**KIRKLEES METROPOLITAN COUNCIL
INVESTMENT & REGENERATION SERVICE**

Reference No:	2022/62/90738/W
Site Address:	8, Oaklands Drive, Dalton, Huddersfield, HD5 8PR
Description:	Erection of two-storey side extension and associated alterations
Recommending Officer:	Hubert Lam

Officer Report

2022/90738 – 8 Oaklands Drive, Dalton, Huddersfield, HD5 8PR

PROPOSED BLOCK PLAN
SCALE 1:200@A1

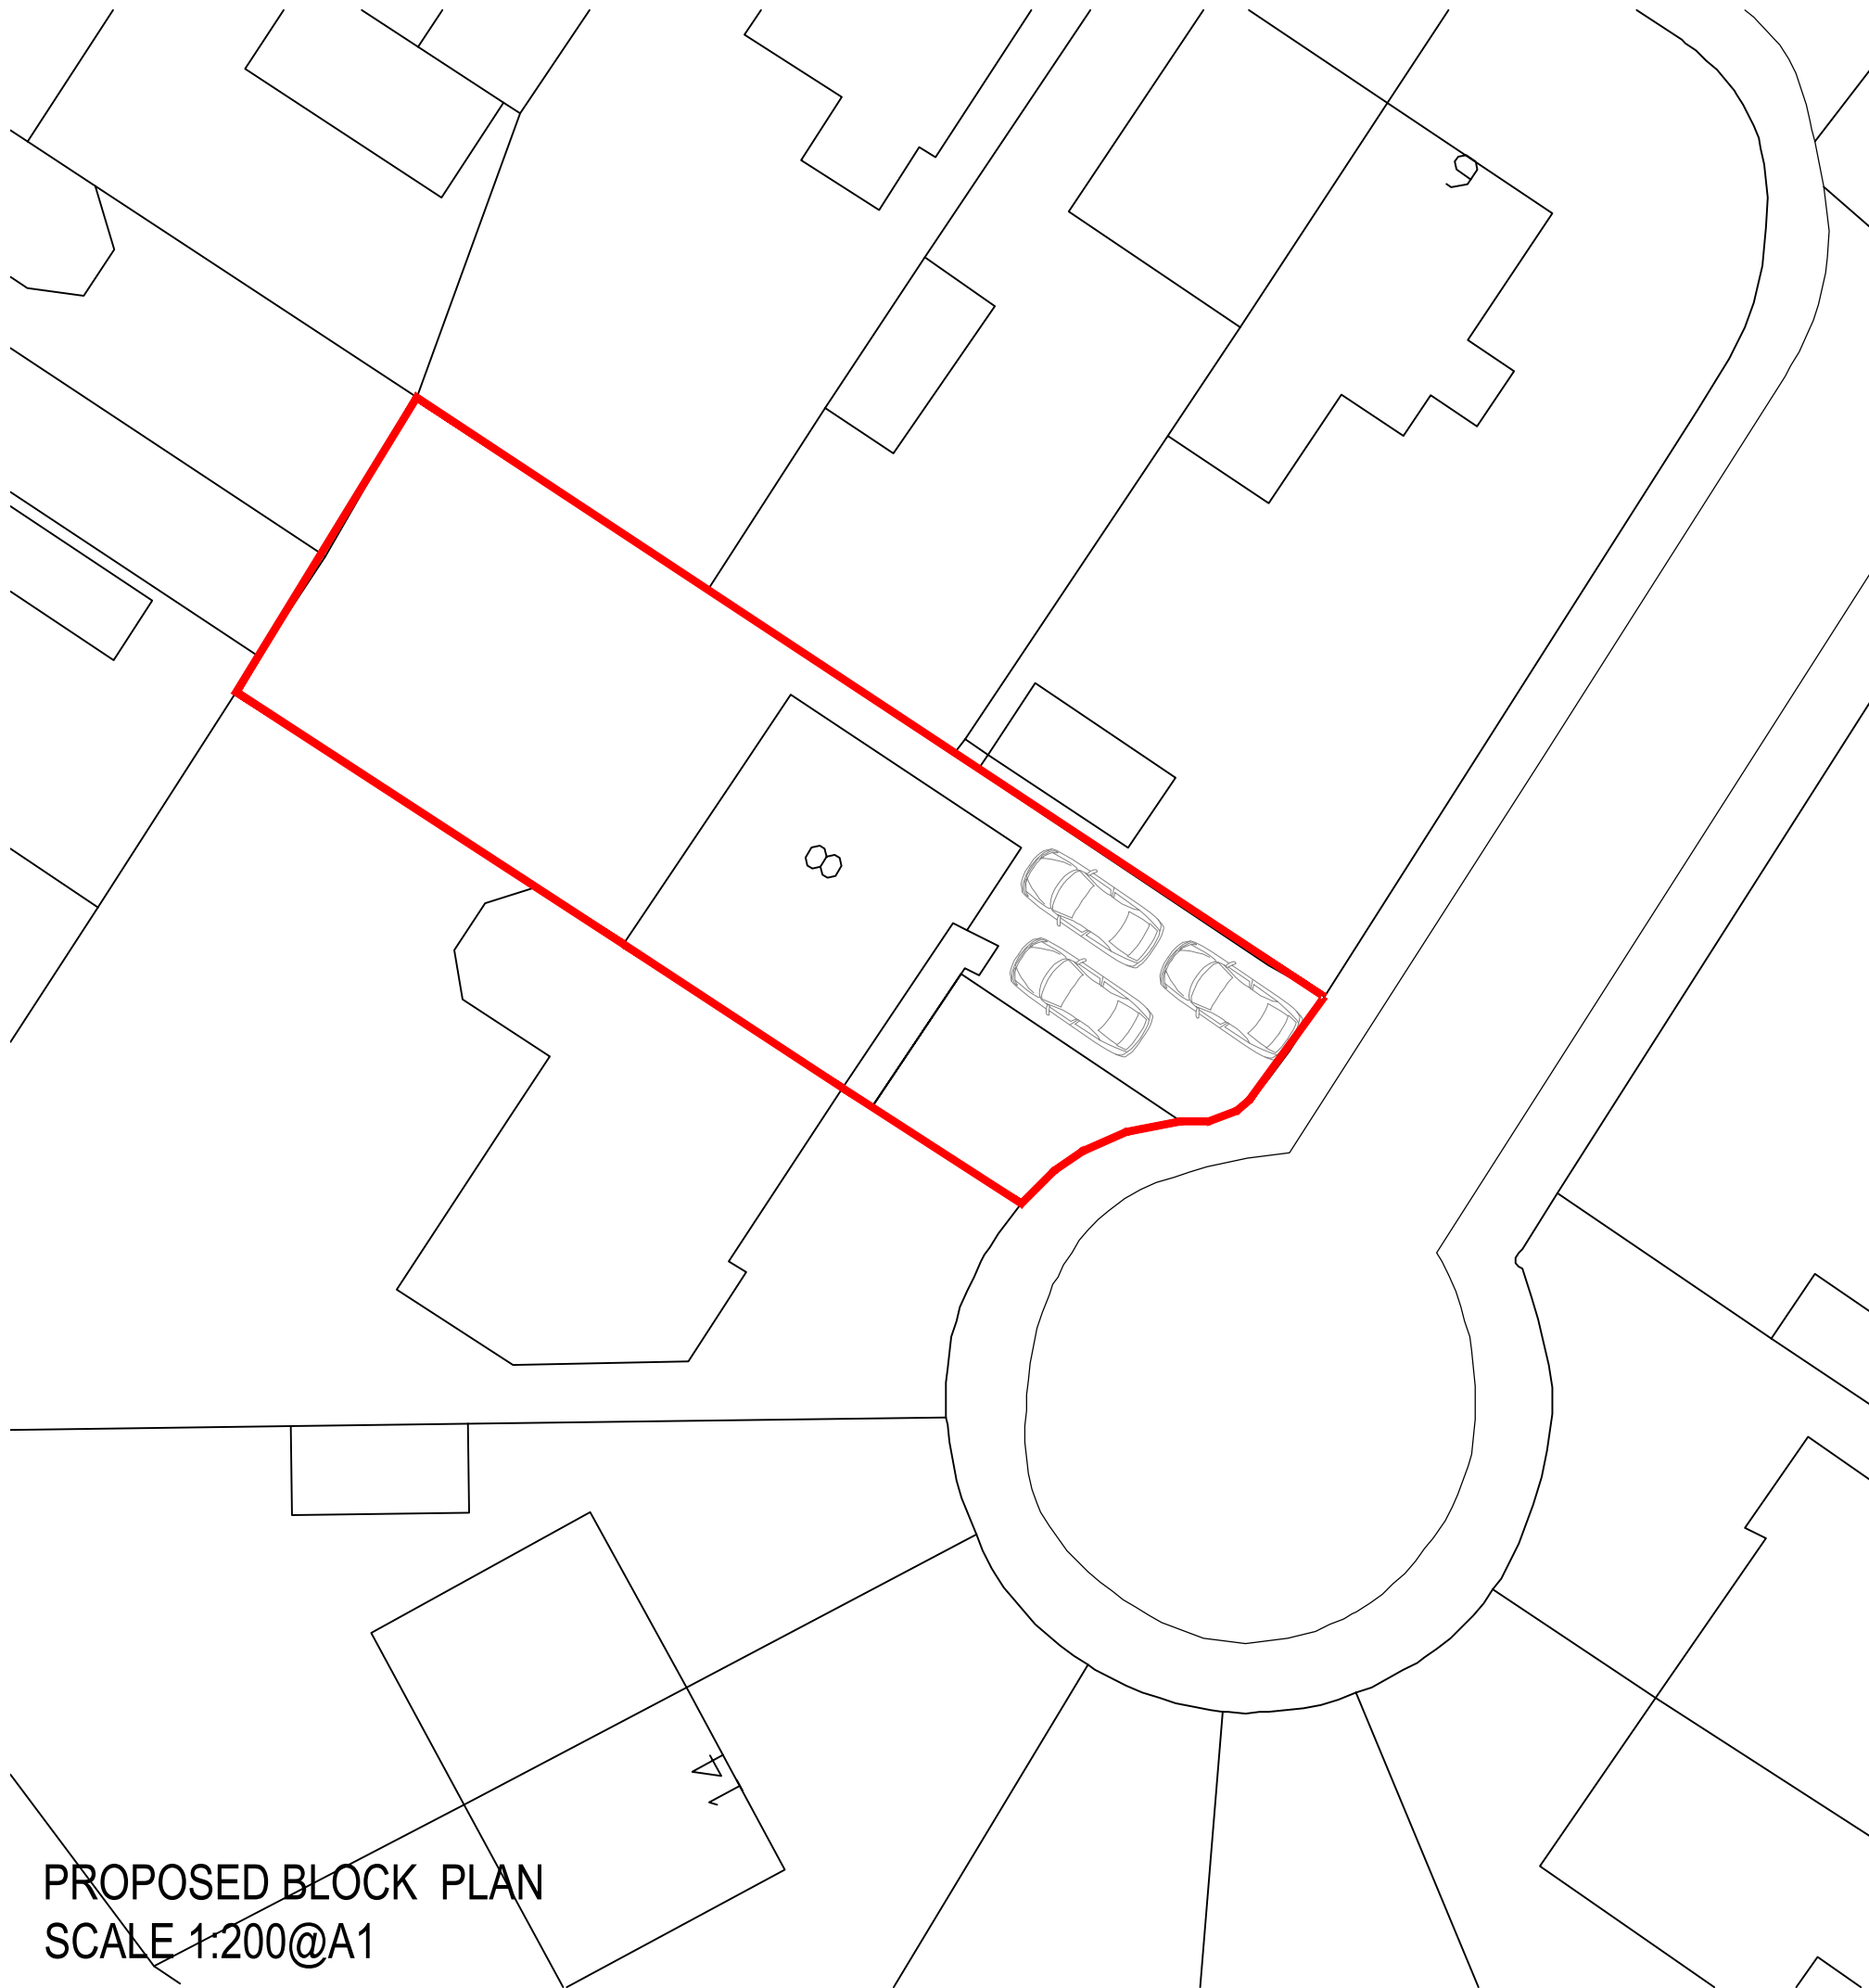
The block plans displays that the site would provide at least 3no on-curtilage parking spaces in the form of its front private drive / hardstanding area, but the dimensions of the spaces displayed are below what is considered acceptable for an external parking space (Kirklees guidance being a minimum of 5m x 2.4m— and it is considered that two spaces are more likely to be provided to the front. However, given the sustainable location of the site with access to frequent public transport and services and that two of the bedrooms are likely to form single bed bedrooms, it is considered that this is acceptable on balance and that the proposal is unlikely to result in adverse highways safety issues. The proposal is therefore considered to be in accordance with Policies LP21 and LP22 of the Kirklees Local Plan and Chapter 9 of the NPPF.
